# BARNLSLEY

## REFUSAL OF PLANNING PERMISSION

APPLICATION NO. 2010/1336

**Proposal** Erection of detached garage with annex accommodation above (Resubmission)  
**At** 364 Pontefract Road, Lundwood, Barnsley, S71 5JY

RESUBMITTED PLAN Ref 2010/0711  
 PROPOSED DETACHED DOUBLE GARAGE  
 and ANNEX ACCOMMODATION at  
 364 PONTEFRACT ROAD, LUNDWOOD,  
 BARNSELY

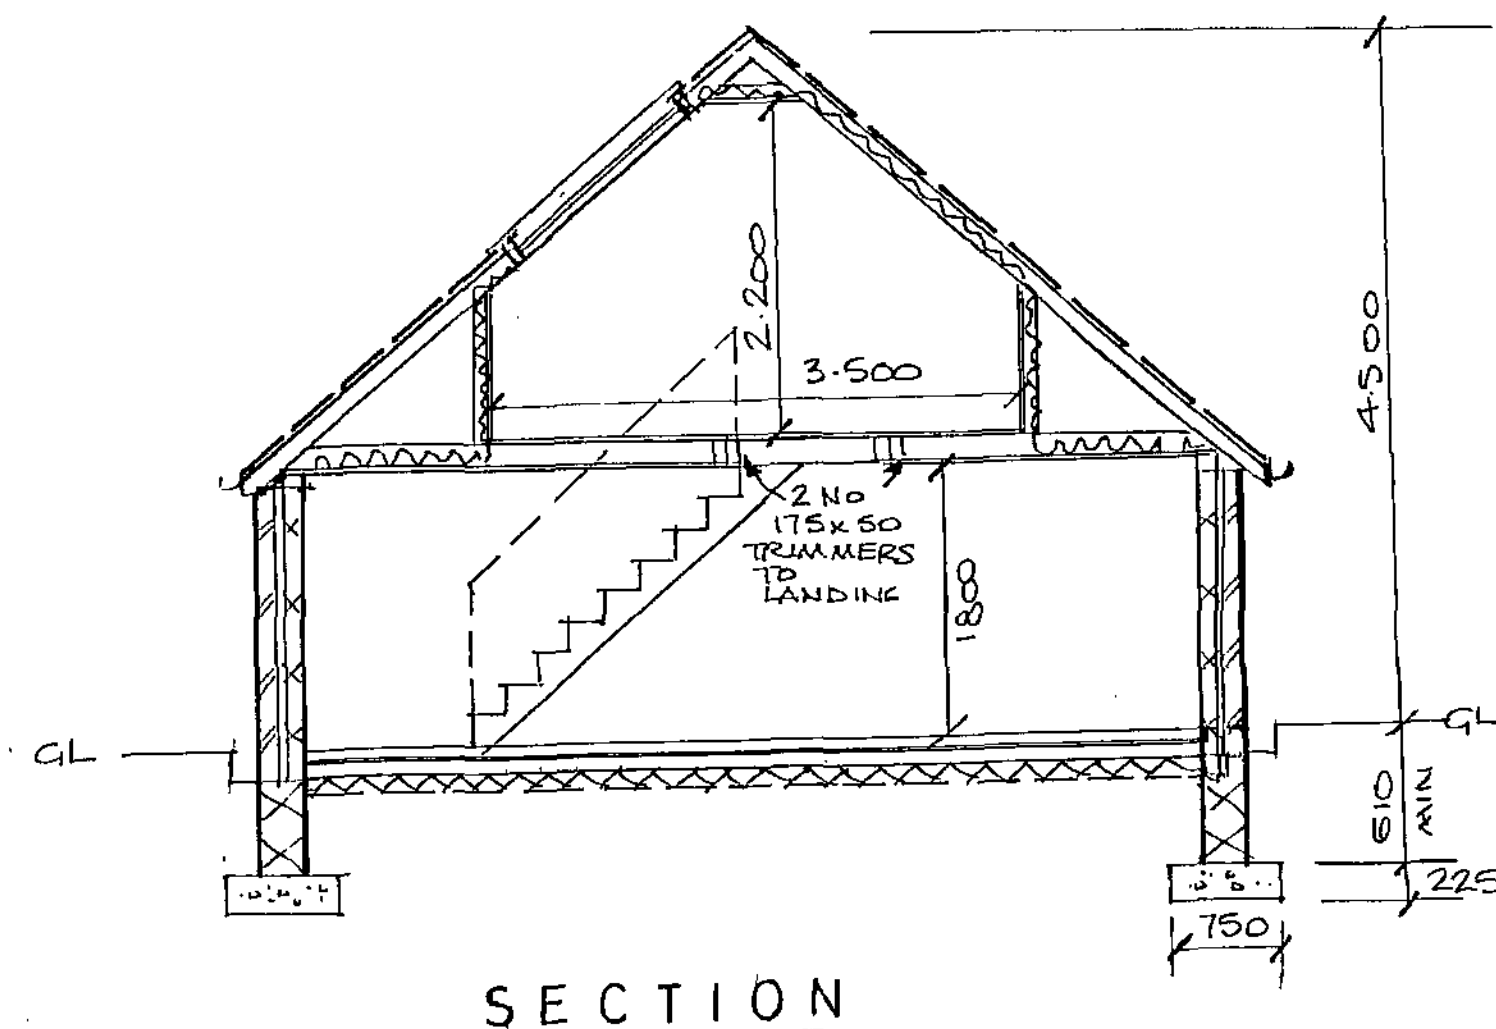
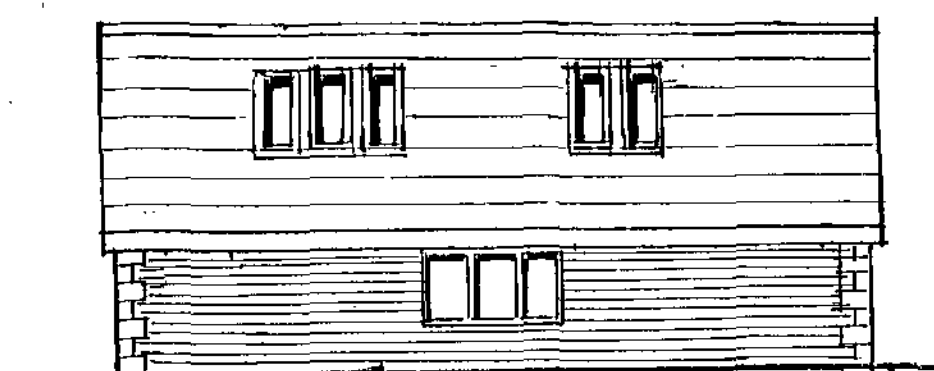
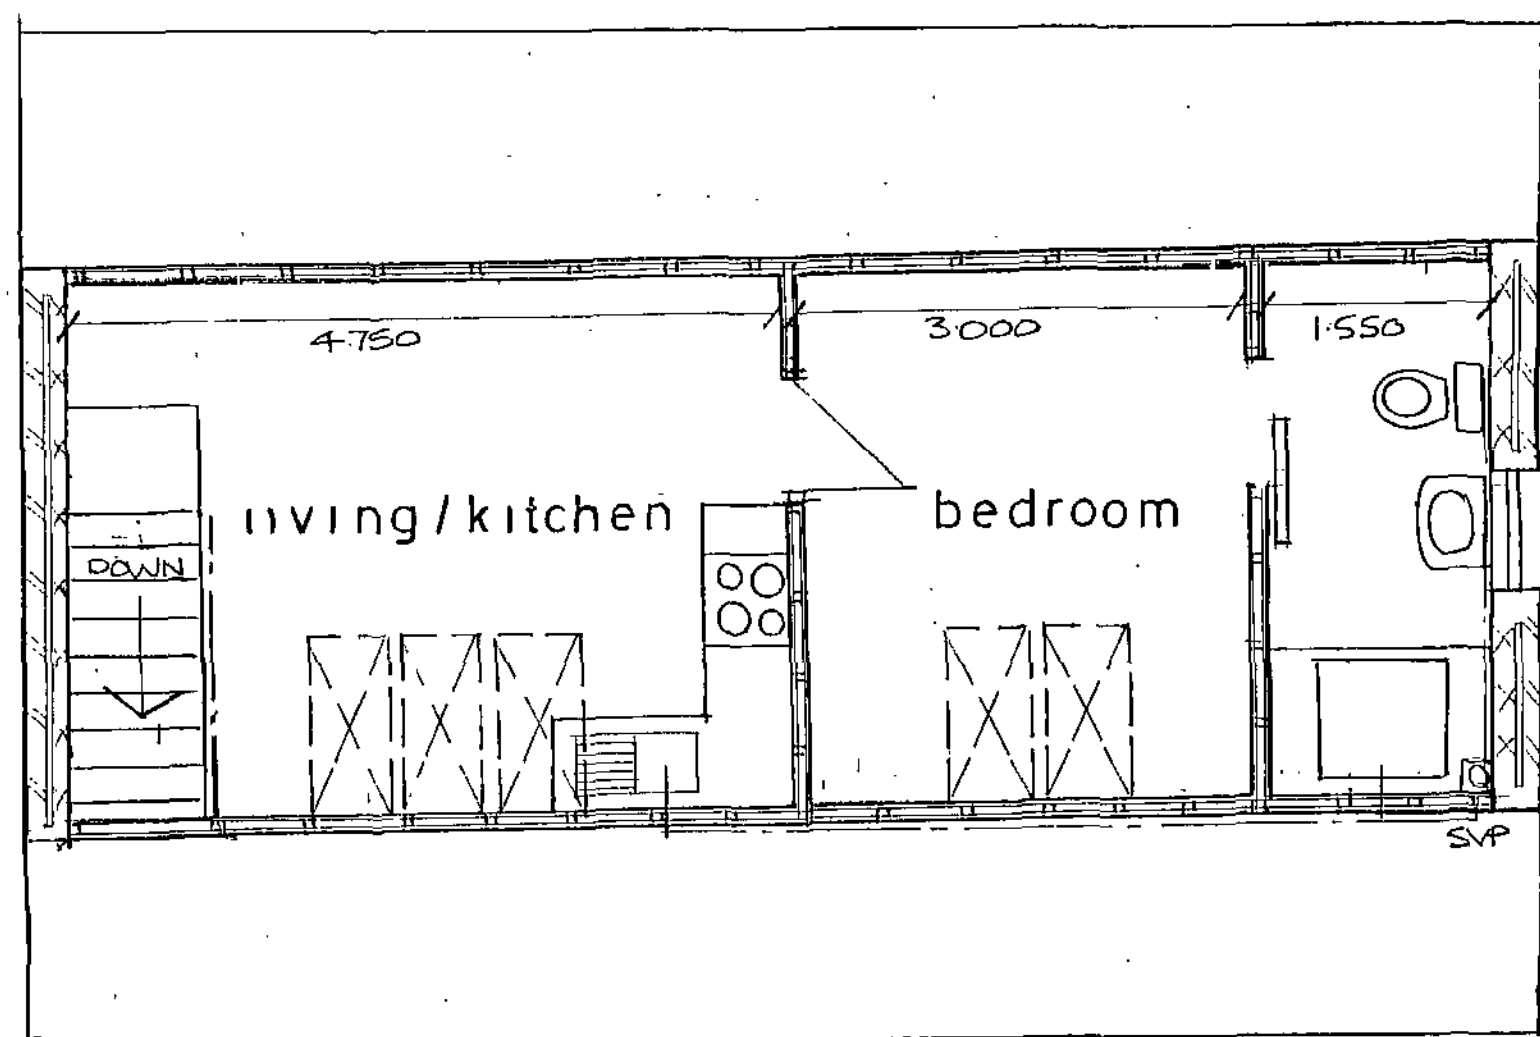
- 1 In the opinion of the Local Planning Authority, the proposed garage/annex would be capable of being occupied as a separate residential unit. In this regard, the proposed internal space and head height within the garage and annex would seriously compromise usability and would not comply with Building Regulations. It would also be materially detrimental to the host dwelling as a result of overlooking and noise and disturbance associated with the proposed access. As such, the proposal is contrary to UDP policies H8A and H8D and the advice in Supplementary Planning Guidance Note 3 - Infill Residential Development.
- 2 In addition, the proposed garage and annex would be contrary to policies H8F and BE6 of the Unitary Development Plan in that its scale and design would fail to respect the character and appearance of the host property by virtue of its height and footprint.
